**RE: Greenwich Hospital Redevelopment – Pallister House  
Summary of Changes and Heritage Commentary**

This letter has been prepared to provide heritage commentary on proposed revisions to the submitted Concept Plan for the redevelopment of the Greenwich Hospital site. The revisions to the proposal reflect feedback received from the NSW Heritage Division following a visit to the site on the 1<sup>st</sup> of July 2019. The amendments have been prepared by Bickerton Masters Architects with advice from Taylor Brammer, heritage landscape specialist, and NBRSArchitecture, the nominated heritage consultant for the project, and involve a refinement of the development at the interface with the State heritage listed Pallister House.

DRAWING TITLE:
OVERALL FLOOR PLAN - SITE LEVEL 2
DATE:
AUGUST 2019
DRAWN:
CM
PROJ:
1213
PROJ ARCH:
BF
DRAWING:
IN.11
SCALE:
As indicated @ A1
REVISION:
P7

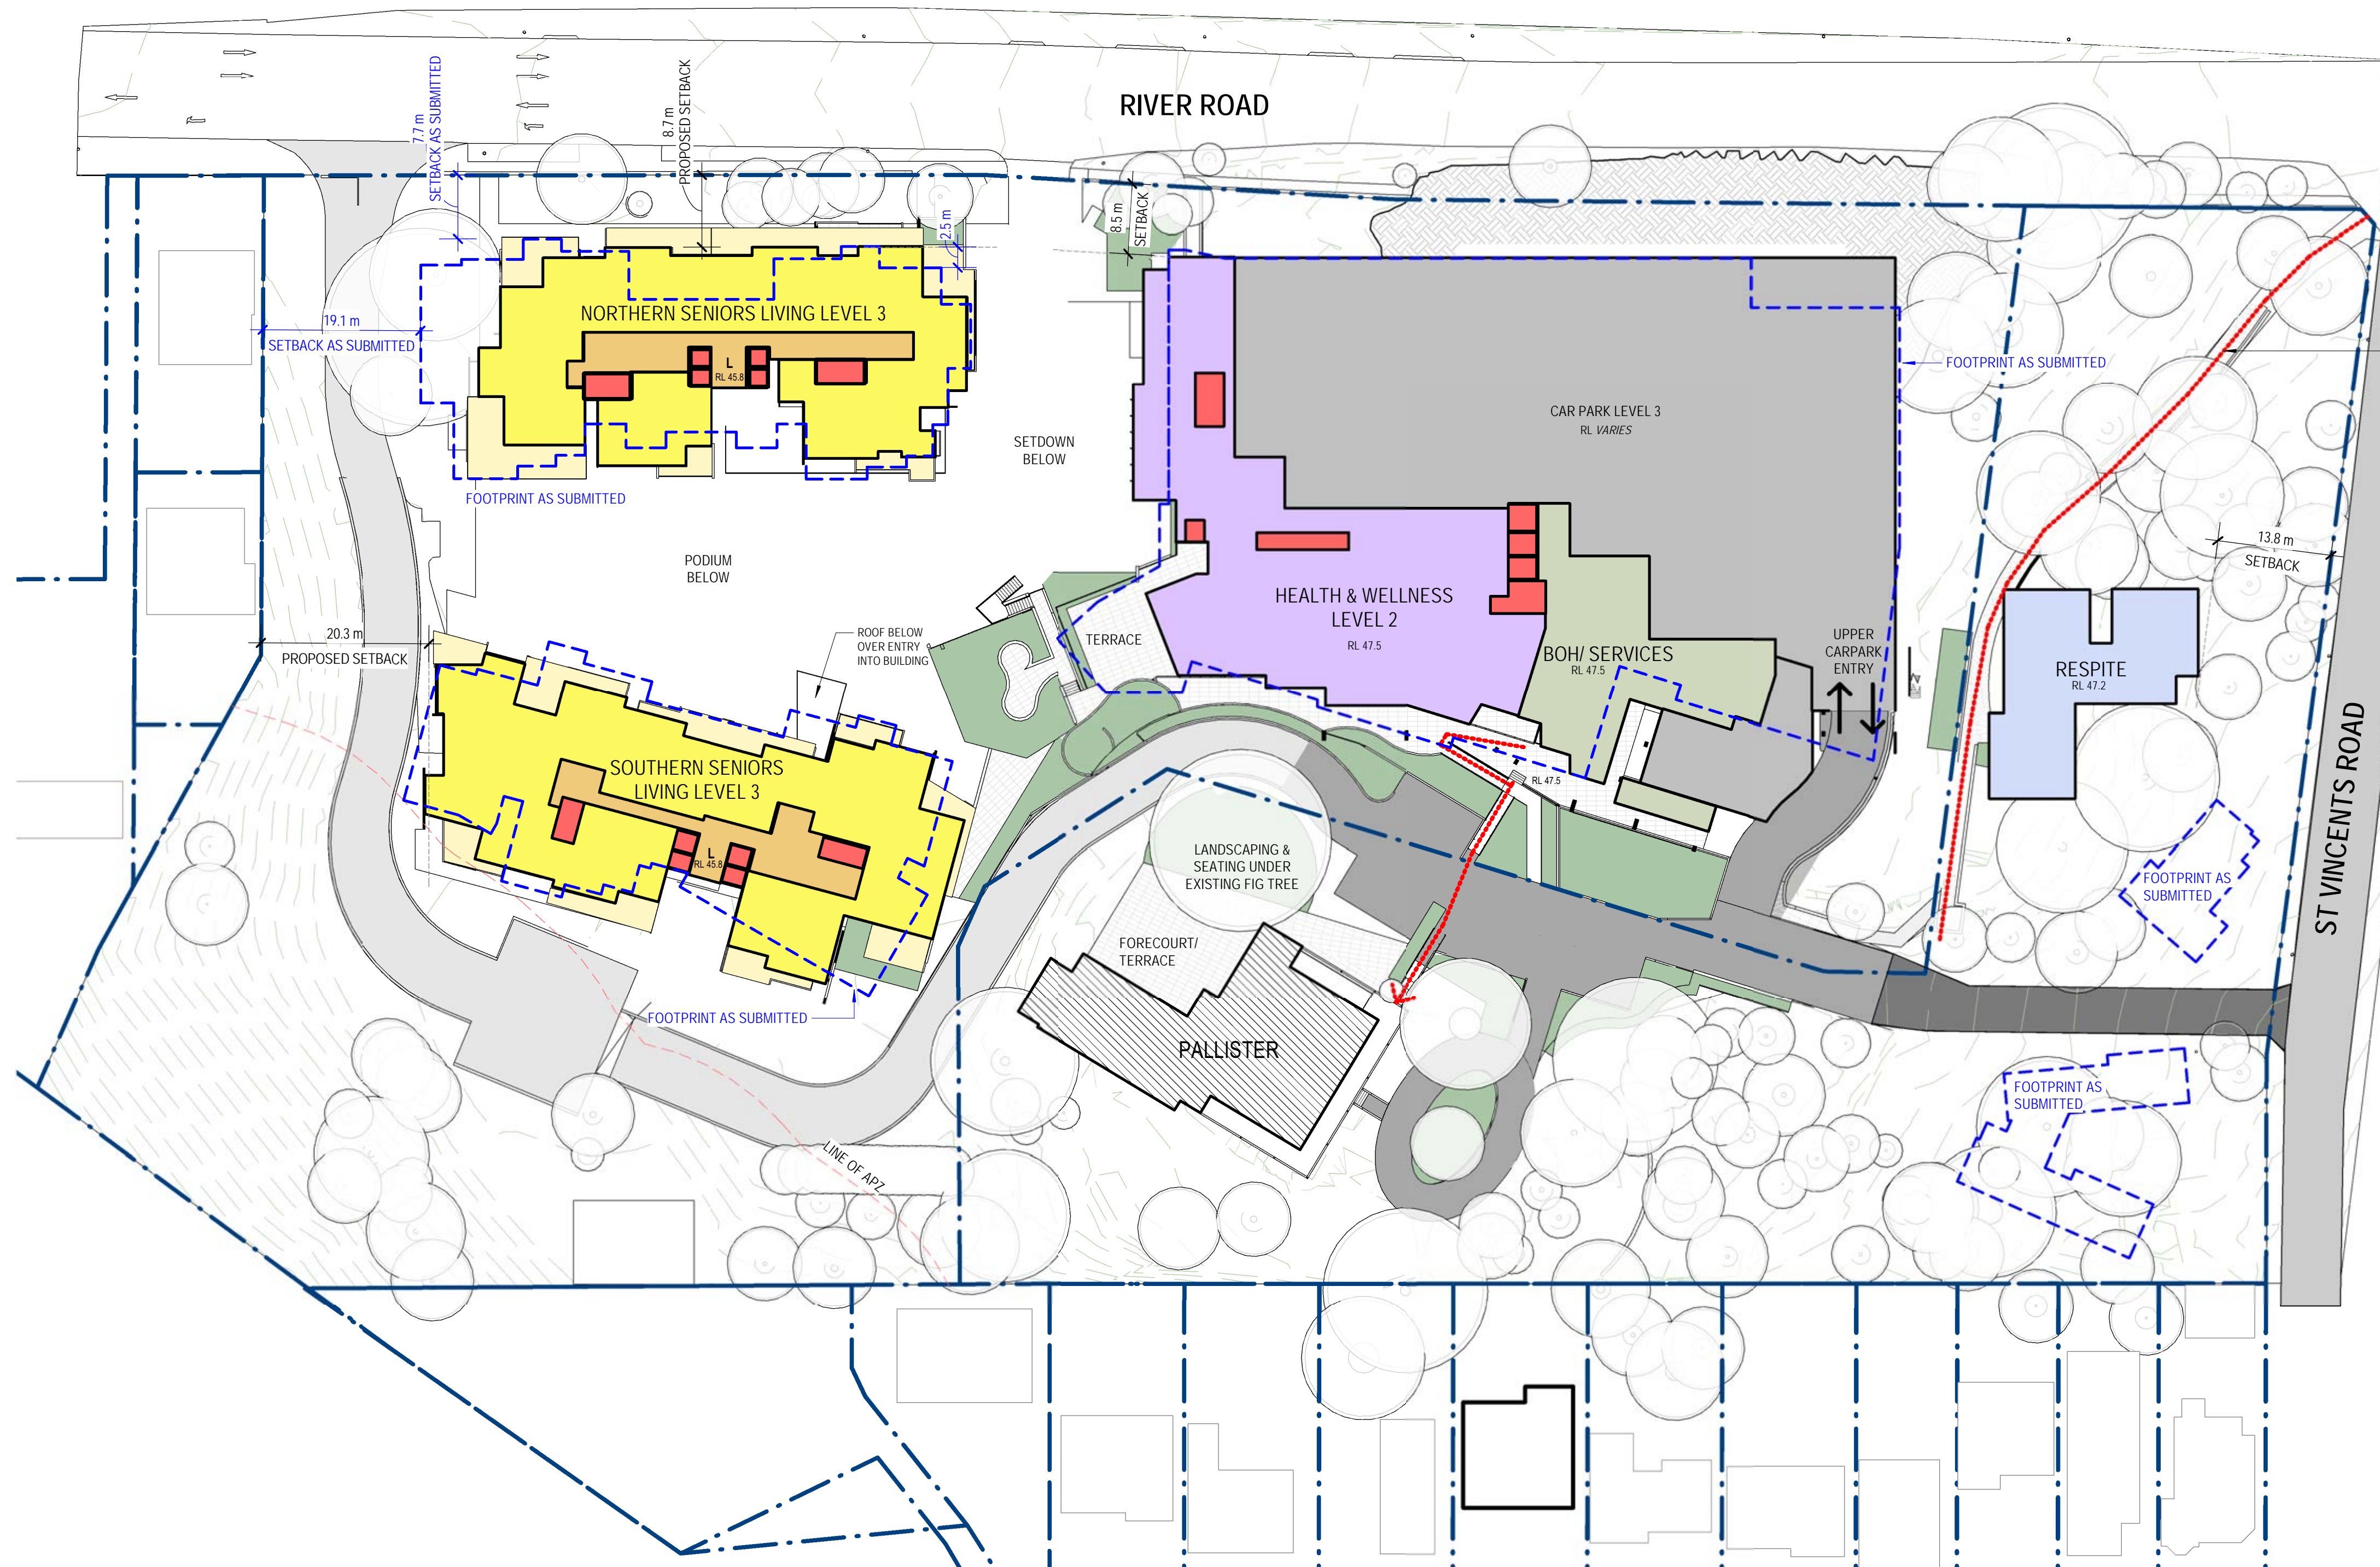
- *The amended concept design now responds to some of the key elements of the Bridle path and Heritage Landscape that are evident in old photographs and drawings such as Augustus Aley's 1938 Landscape plan.*
- *Like the original path, the reinterpreted Bridle path turns toward the north-east corner of Pallister House once it passed the corner of the site Curtilage. The character of the proposed setting is an open "Gardenesque" landscape with clearer views of Pallister from the East.*
- *The pedestrian connection between the proposed hospital and the north-east corner of Pallister House is located in the same place as a former pergola structure that is evident in historic photos.*

The proposal retains a pathway generally along the line of the existing path providing pedestrian access to Pallister, much in the same way as access is currently provided. The location of the Respite building has been determined in relation to the path as well as the existing trees to be retained.

The Respite building has an acceptable heritage impact as it has been located to enable the retention of the pathway in an enhanced curtilage in response to the submissions. Taylor Brammer (heritage landscape specialists) have been commissioned to provide landscape advice and design services across the project. This advice will include specifying appropriate plantings, pathway materials and edging details to support the interpretation of the earlier character of the Pallister carriage loop, gardens and pathways.

DRAWING TITLE:
SITE SECTIONS - PALLISTER HOUSE
DATE:
AUGUST 2019
DRAWN:
JC, EC
PROJ:
1213
PROJ ARCH:
BF
DRAWING:
IN.32
SCALE:
As indicated @ A1
REVISION:
P6

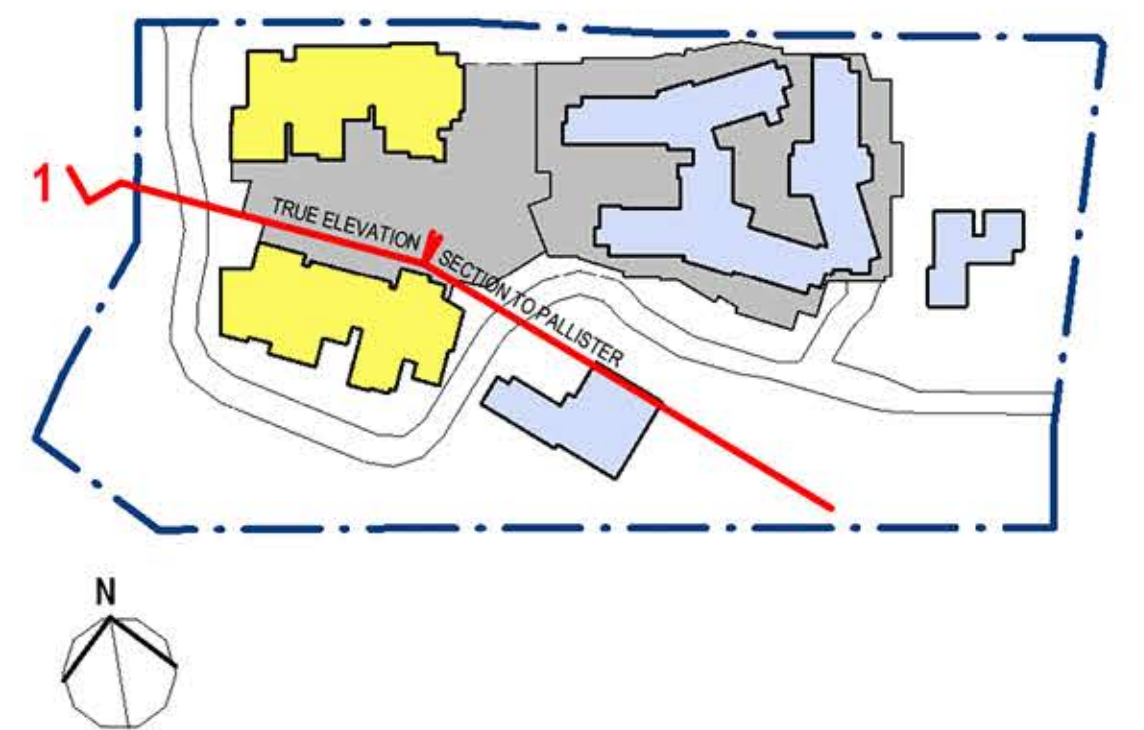
Modifications to the proposal described above have responded to the feedback by strengthening the relationship of the proposed hospital podium to the scale of Pallister and in reducing the bulk of the adjacent built form. Further articulation of the façade of the main building above the podium acts to soften the contrast in building forms. This is further supported through the development of an appropriate set back between the development and Pallister.

The changes to the building form and height to the west of Pallister assist in reducing visual impacts on the background to the heritage building when it is viewed on approach from the direction of St Vincent’s Road.

The proposed form and setbacks allow Pallister to continue to be appreciated in a relatively open setting; a setting which has already been altered over time through the nearby residential development as well as the existing hospital. These changes will be supported by enhancing the garden and pathways around the heritage item and allowing a landscaped frontage to sit within the wider site.
